EL PASO COUNTY STORMWATER MANAGEMENT PLAN CHECKLIST

EPC Project Number: PPR-2245

GRADING AND EROSION CONTROL PLAN

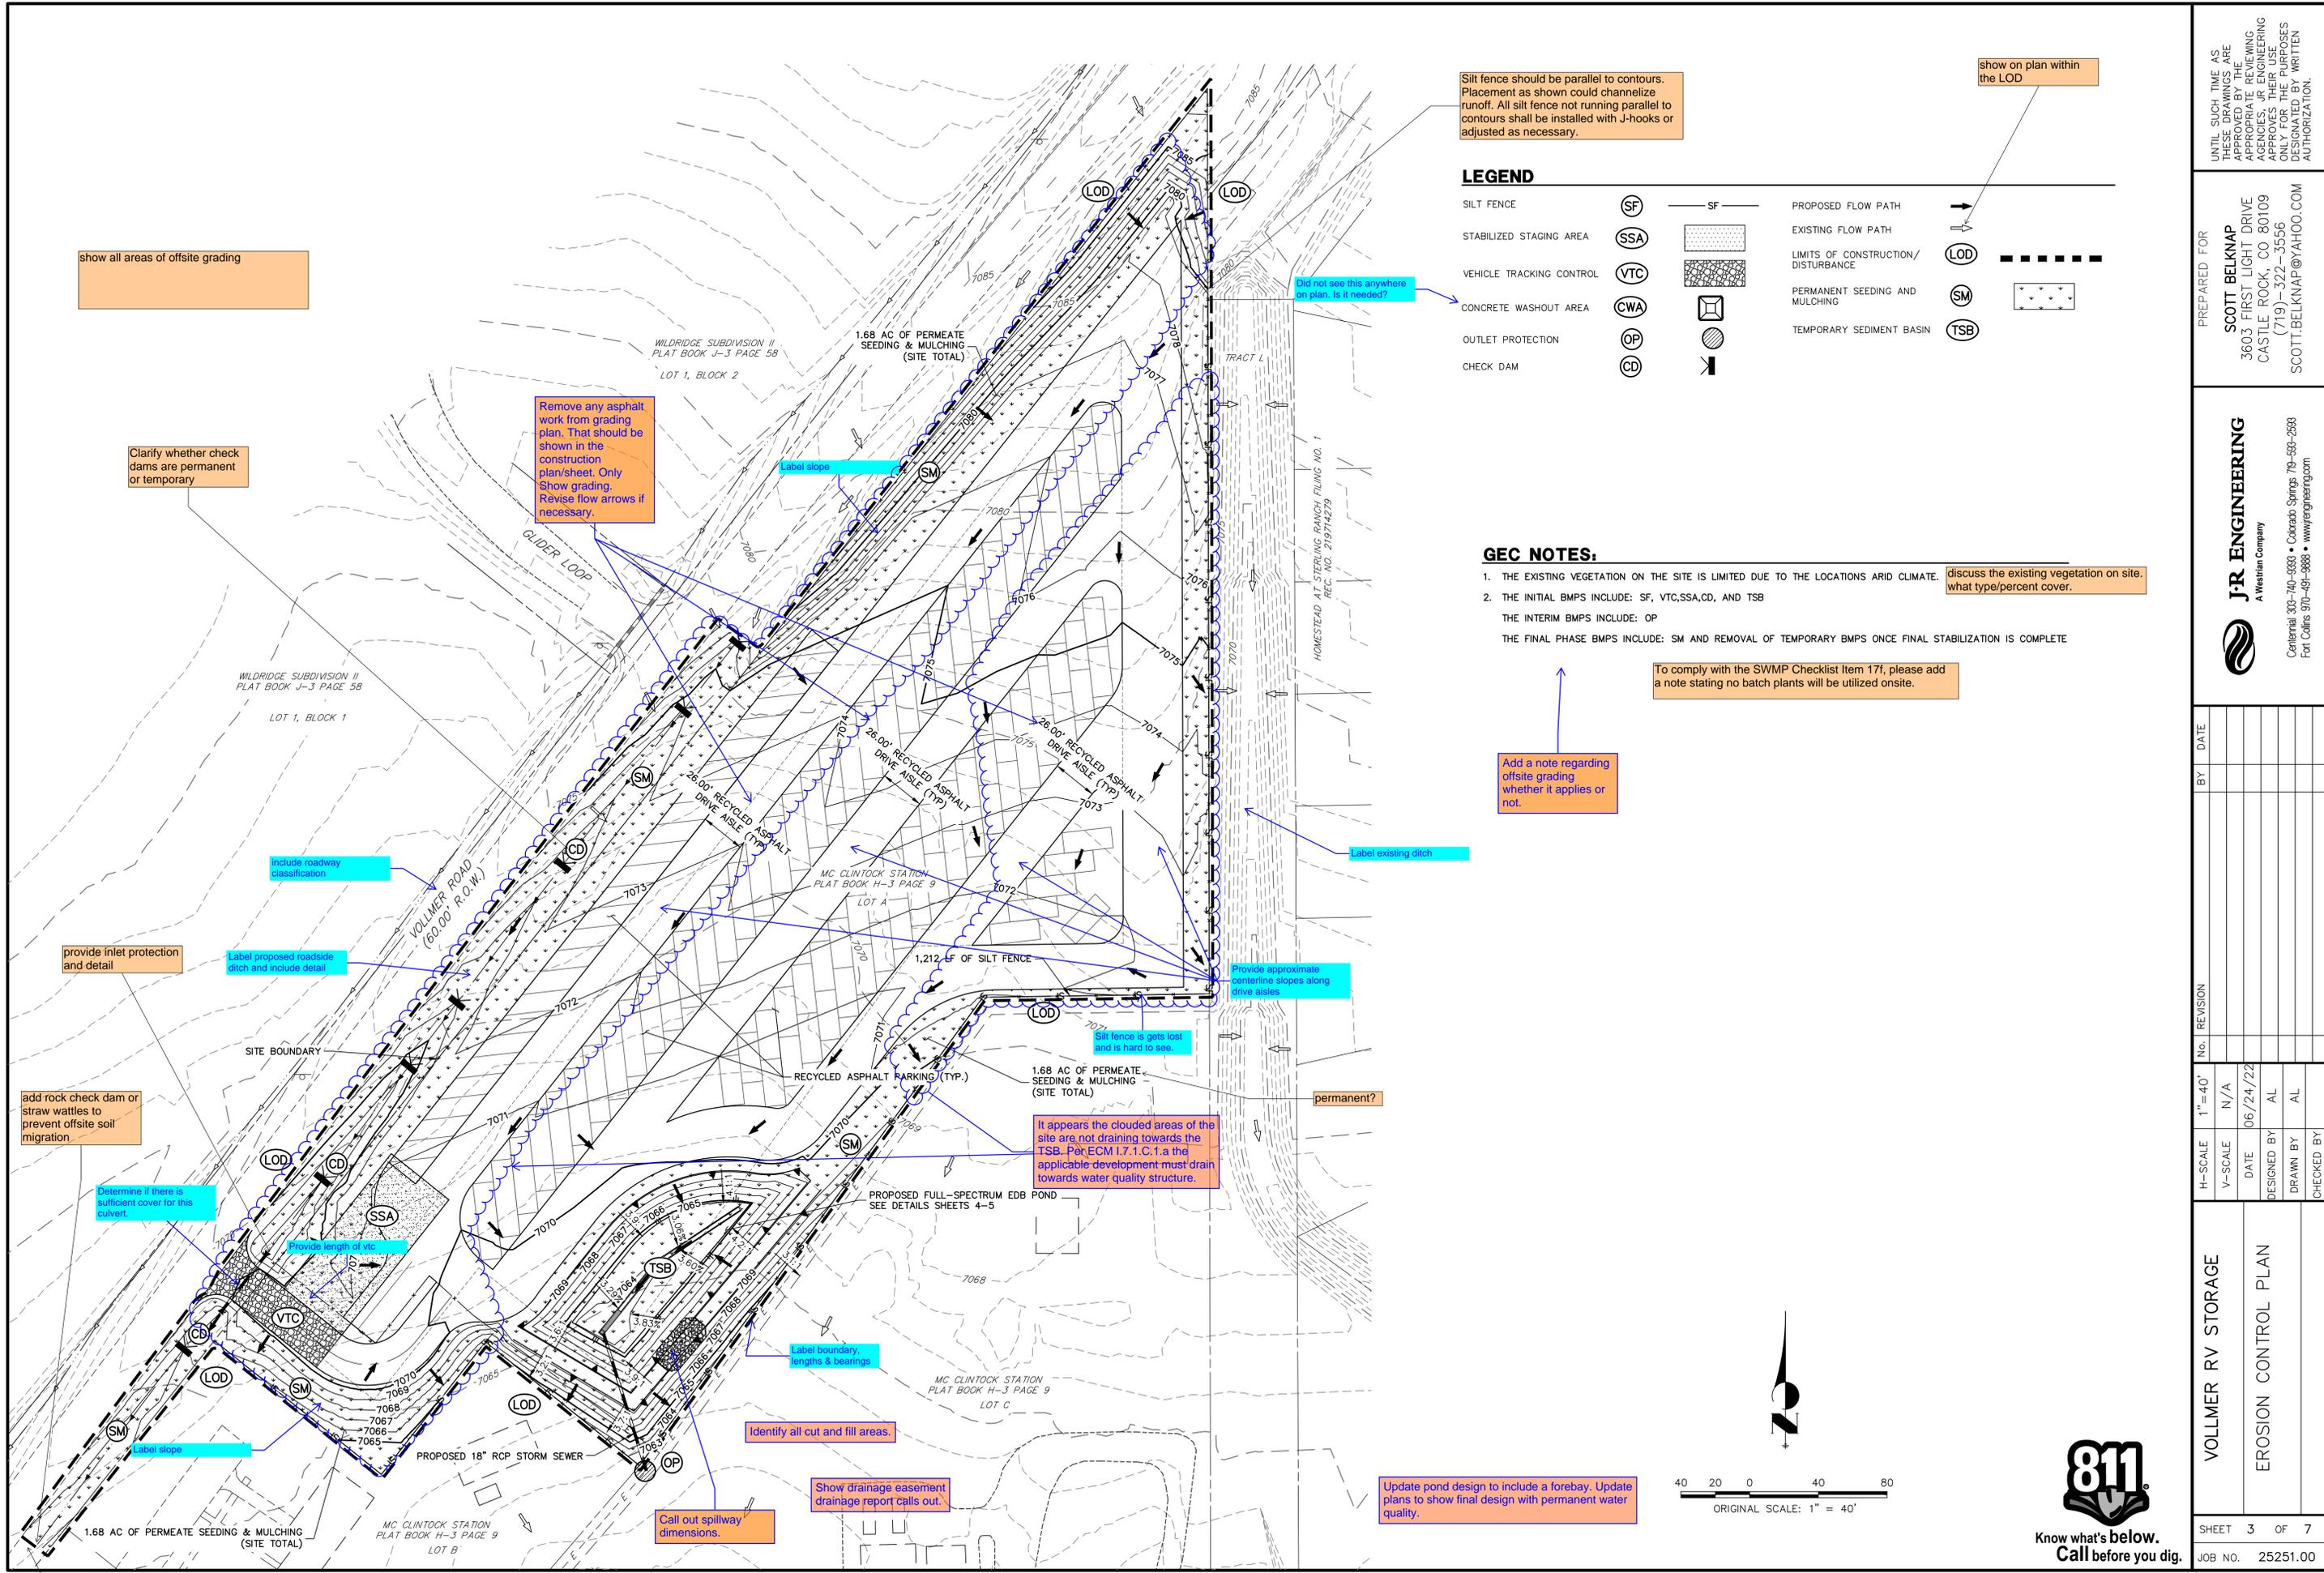
Show areas of cut and fill.
